ENG-CDR20005-R9-CDs-Vollmer.pdf Markup Summary

Subject: Callout
Page Index: 3
Date: 12/18/2021 3:54:50 PM
Author: dsdrice
Color: ■
Layer:
Space:
Page Label: [4] 4 Vollmer Road (south) Interim Sta 23+50 to 33+00 ultimate

**VOLLMER ROAD SOUTHERN TIE-IN TO EXISTING**

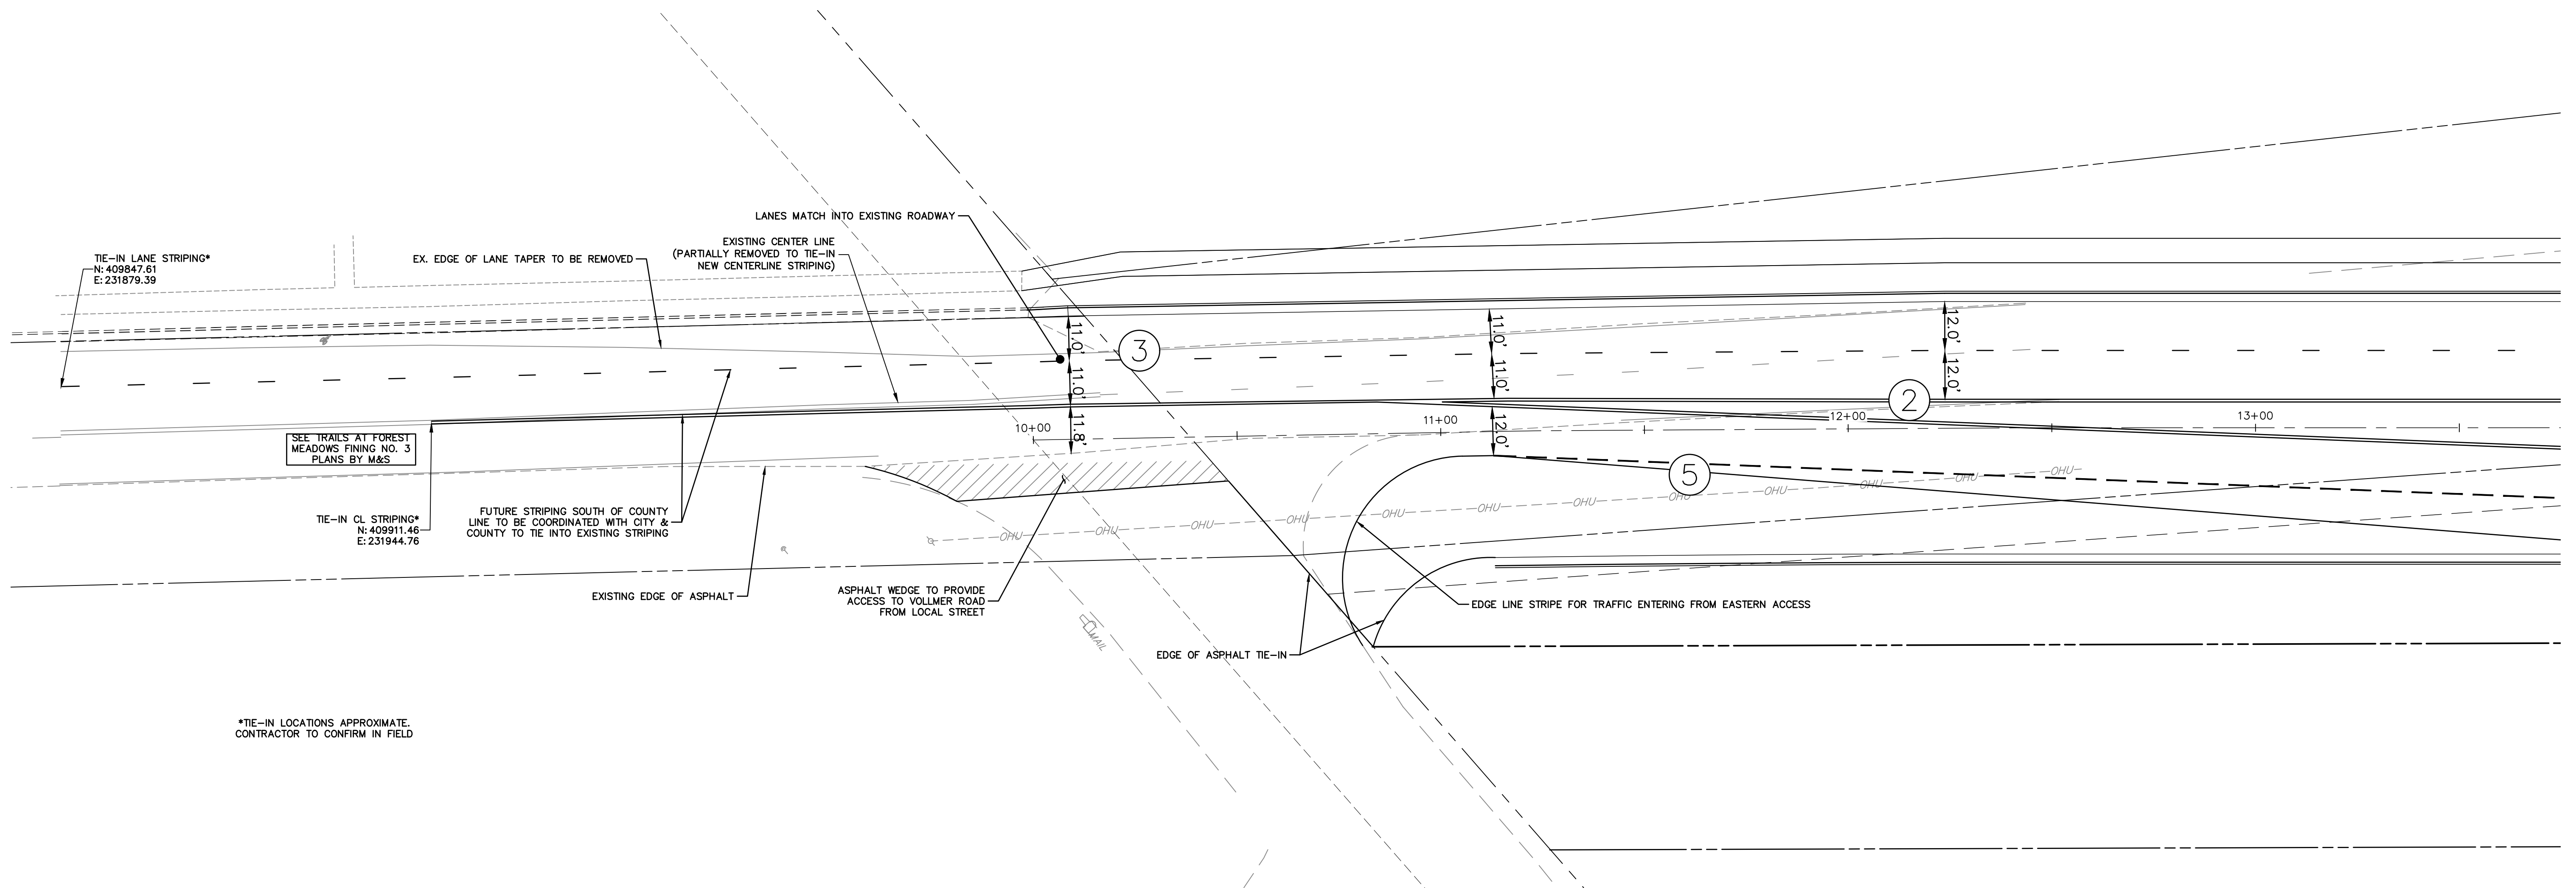
Redirects? See sheet 6

Add median signage including no U-turn, one-way....

move

Shift curb 1' over and taper at beginning

Cara Dawn View (existing sign)?

Delete this note.

Through lane redirect is now 20:1 and begins further to the south.

The following signs have been added:
-No left turn (R3-2L) for SB traffic on Vollmer at the Alzada intersection
-No left turn (R3-2L) for WBR traffic out of Alzada
-One way (R6-1R) for Alzada outbound traffic
-No U-turn (R3-4) sign at south end of median for southbound traffic on Vollmer

R4-7R sign has been moved but not as directed. The sign is now at the north end of the interim raised median.

Curb has not been shifted, as it is in the ultimate location. The median has only been built where it fits with the new longer taper.

There is no sign for Cara Dawn View as of 8/2021 per Google street view.

Can add note if positive the sign exists now.

Note has been deleted.
